**Re: BP#2016-02284 114 Pine Street - Plan review comments**

From: Laurie Leader <lr@portlandmaine.gov>  
To: schnellag <schnellag@aol.com>  
Sent: Tue, Sep 20, 2016 1:25 pm  
Subject: BP#2016-02284 114 Pine Street - Plan review comments

client PA RENOVATIONS
PINE STREET
INITIAL DESIGN
26JUL-2016

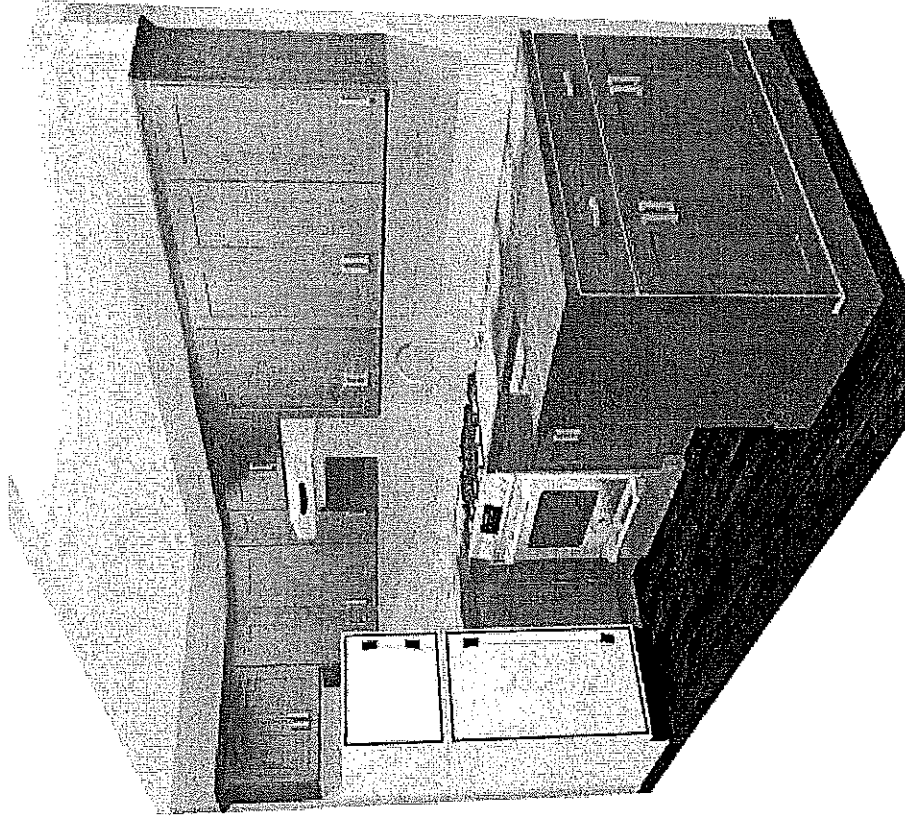
1. Clarify which unit or units are being renovated? What floor and unit number?
2. The site plan provided is very difficult to read as the print is too light. Please resubmit more legible plans.
3. Is the bathroom and kitchen layout remaining the same?
4. Clarify what dry wall work is being done.

1. Unit #1 on the 1st floor.
2. I will darken the site plan lines and refax to you this evening at 874-8716. I don't have the drawing with me at work.
3. The bathroom layout is the same. The kitchen sink and stove were moved from one wall to the other. We added more counter space and cabinets.  
We moved the door from the kitchen to the bedroom about 4 feet, from one kitchen corner to the other (along the same wall). This was originally a single family home, and this apartment was created many years before we purchased it, so this was never a load bearing wall. The kitchen, bath, and bedroom were all created/ added to make this an apartment when it became a multi-unit.
4. We had new drywall installed over the existing plaster ceilings and bedroom and living room walls. We had new drywall installed in the bathroom and along one living room and the kitchen area walls.
